From: Paul Cann
Sent: 21 June 2017 15:04
To: Planning.Responses
Subject: RE: Planning Consultation on EP/81/17/DOC

Site Address: The Martlets Sea Road East Preston BN16 1JP

Description of Works: Application for approval of details reserved by conditions imposed under planning appeal APP/C3810/A/13/2199149 (EP/82/12) relating to Condition No. 7 (Surface water drainage)

Proposed Surface Water
Soakaway (To serve roof
slopes only)

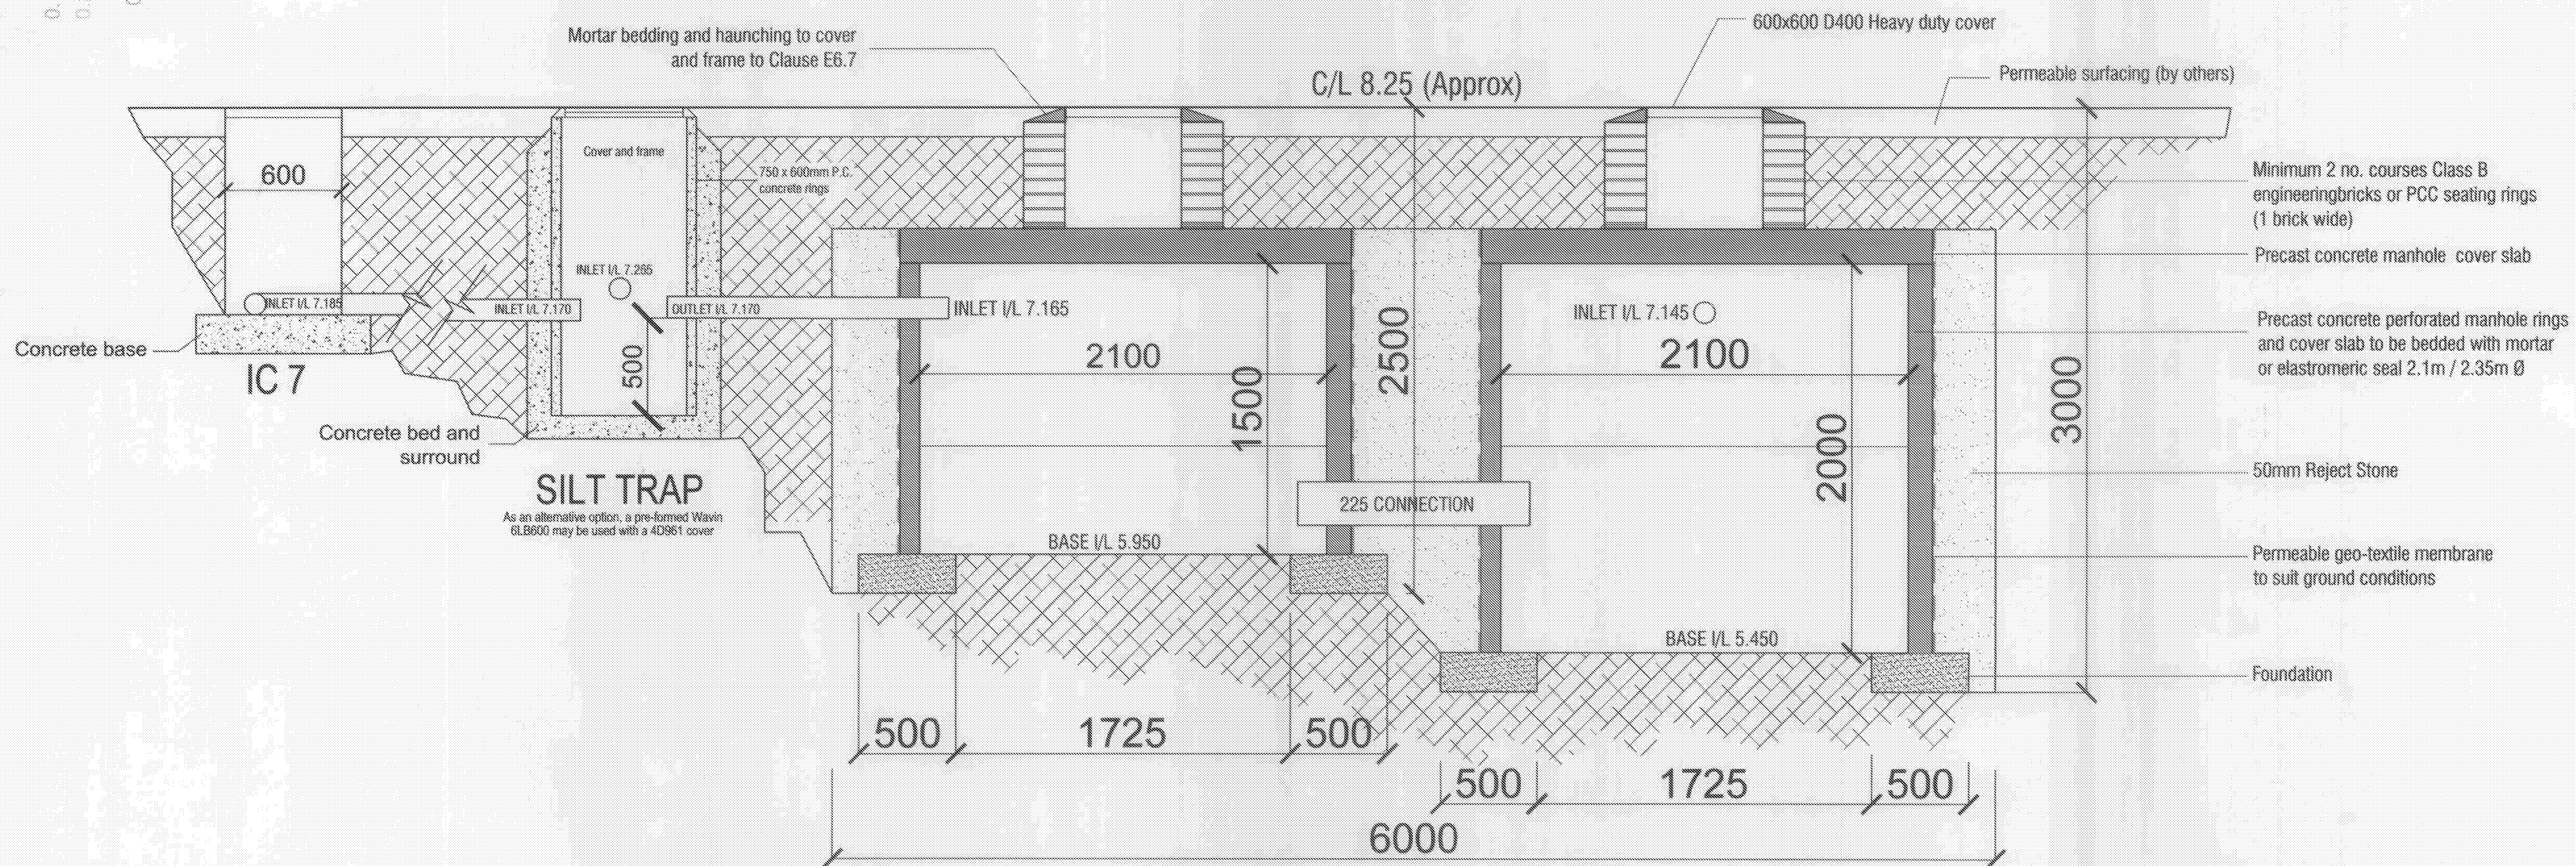
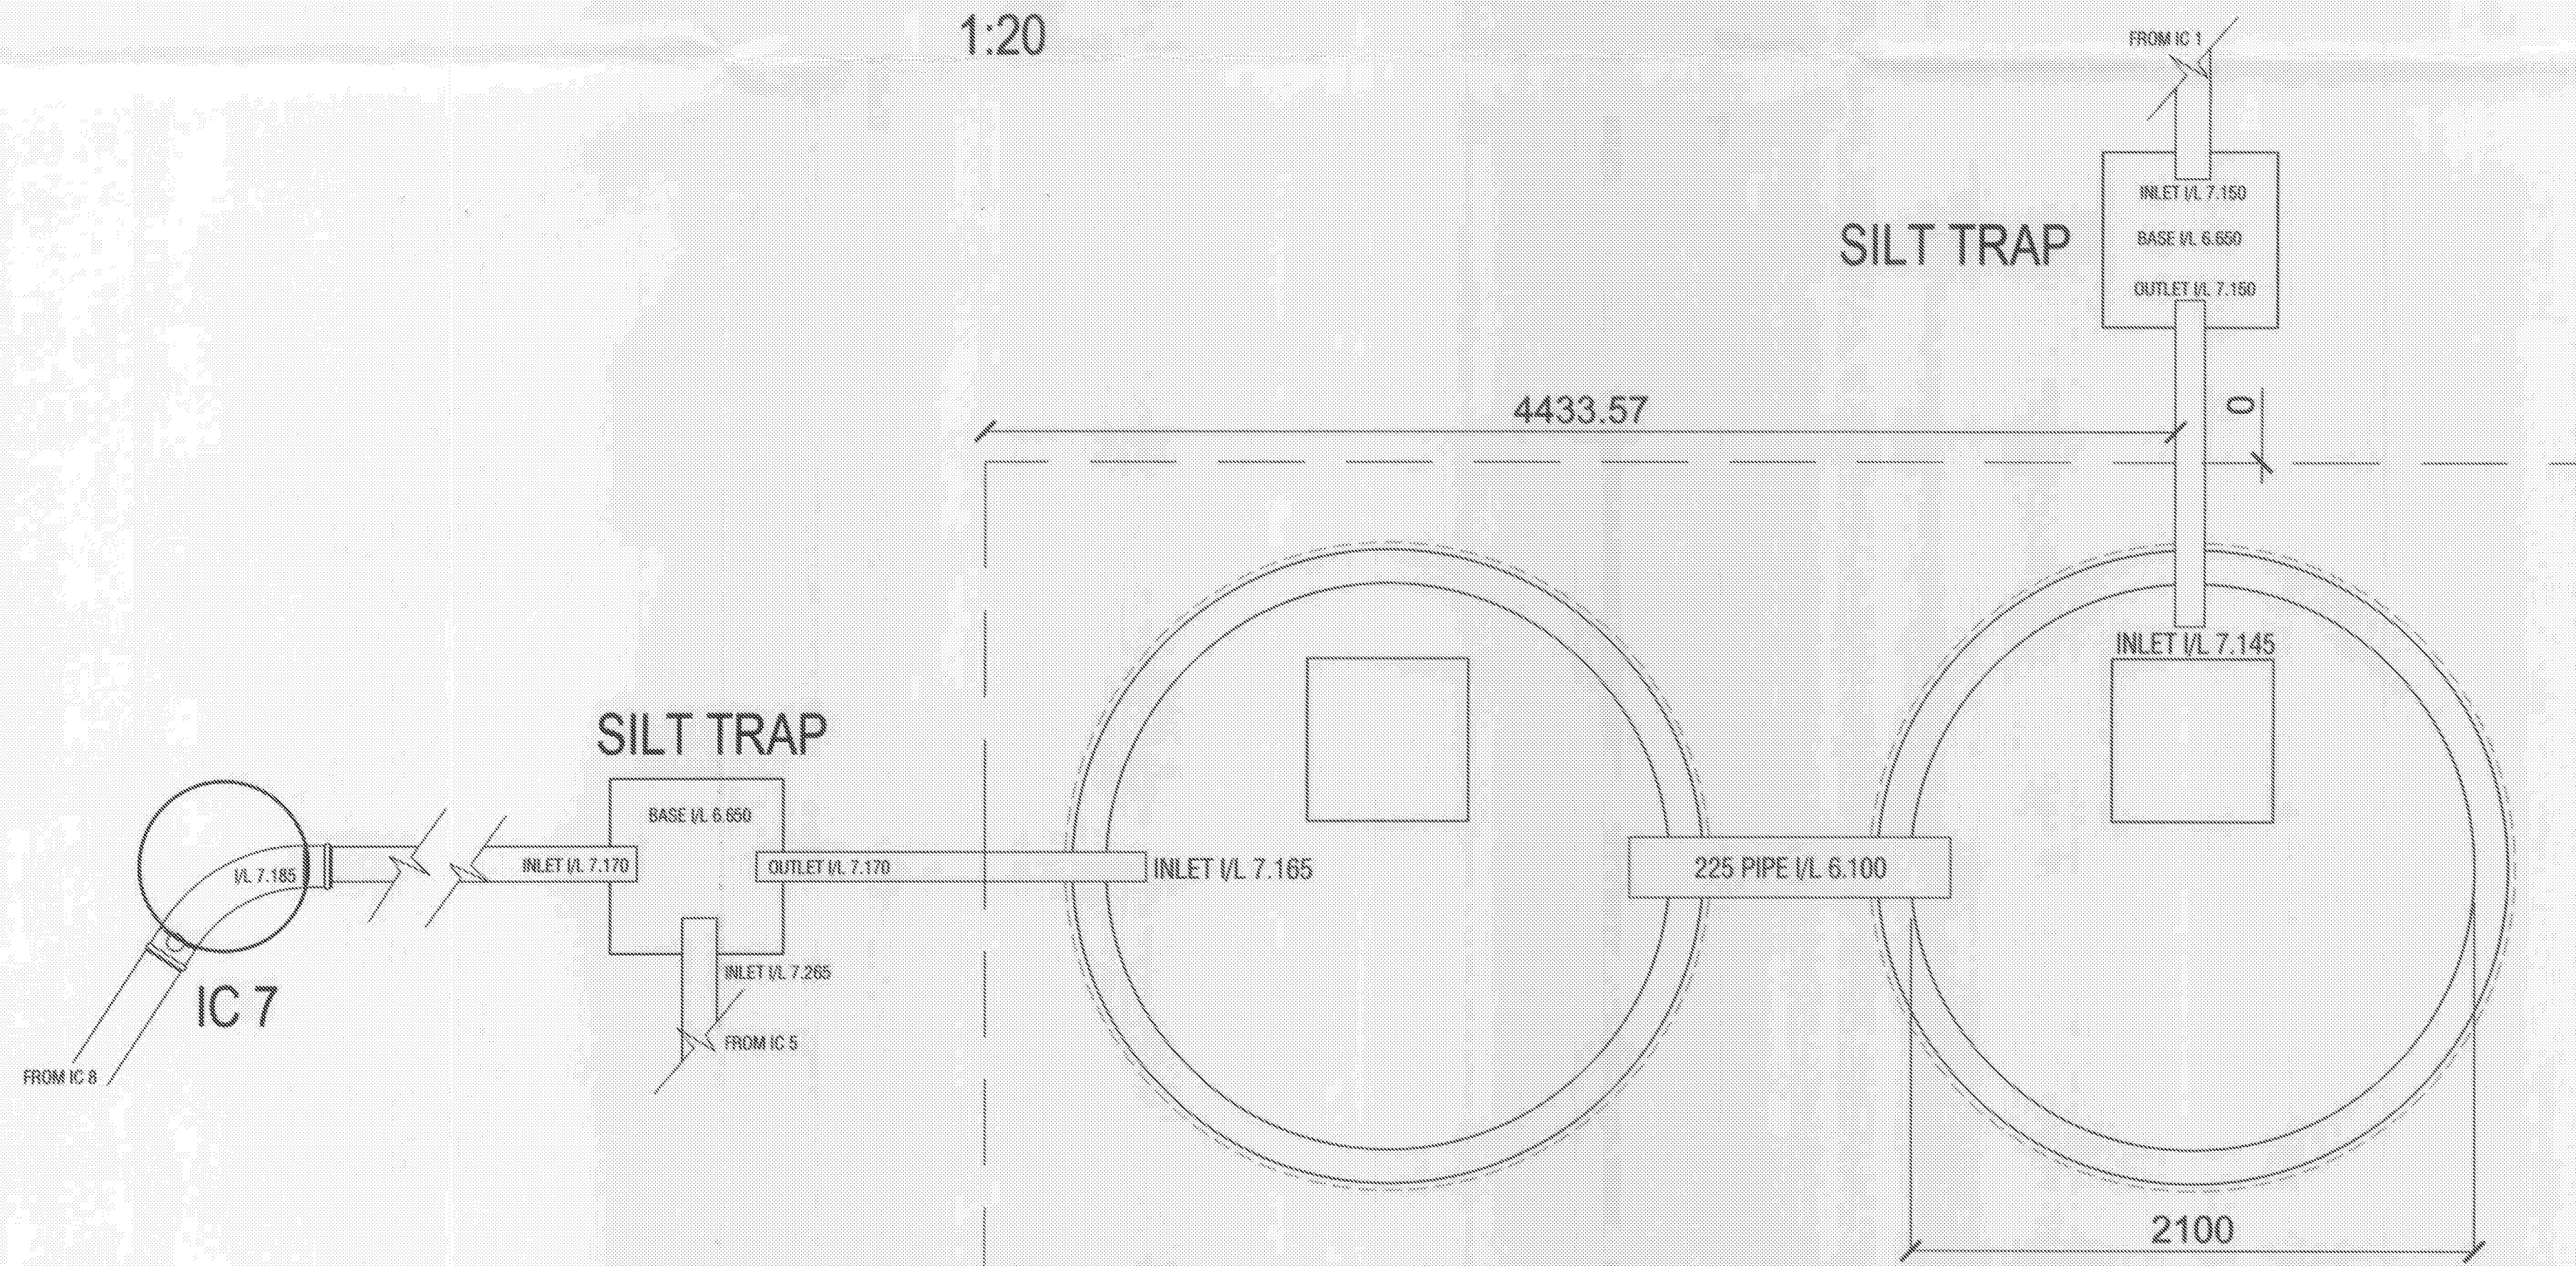
Regarding the surface water drainage scheme, I am unable to consider the proposals further until such time that the applicant has provided the following to support the design;

1. Winter groundwater monitoring data.
2. Winter percolation testing to BRE 365.
3. Hydraulic calculations to confirm that the 1 in 100 year storm event + 30% allowance for climate change, can be accommodated within the site.
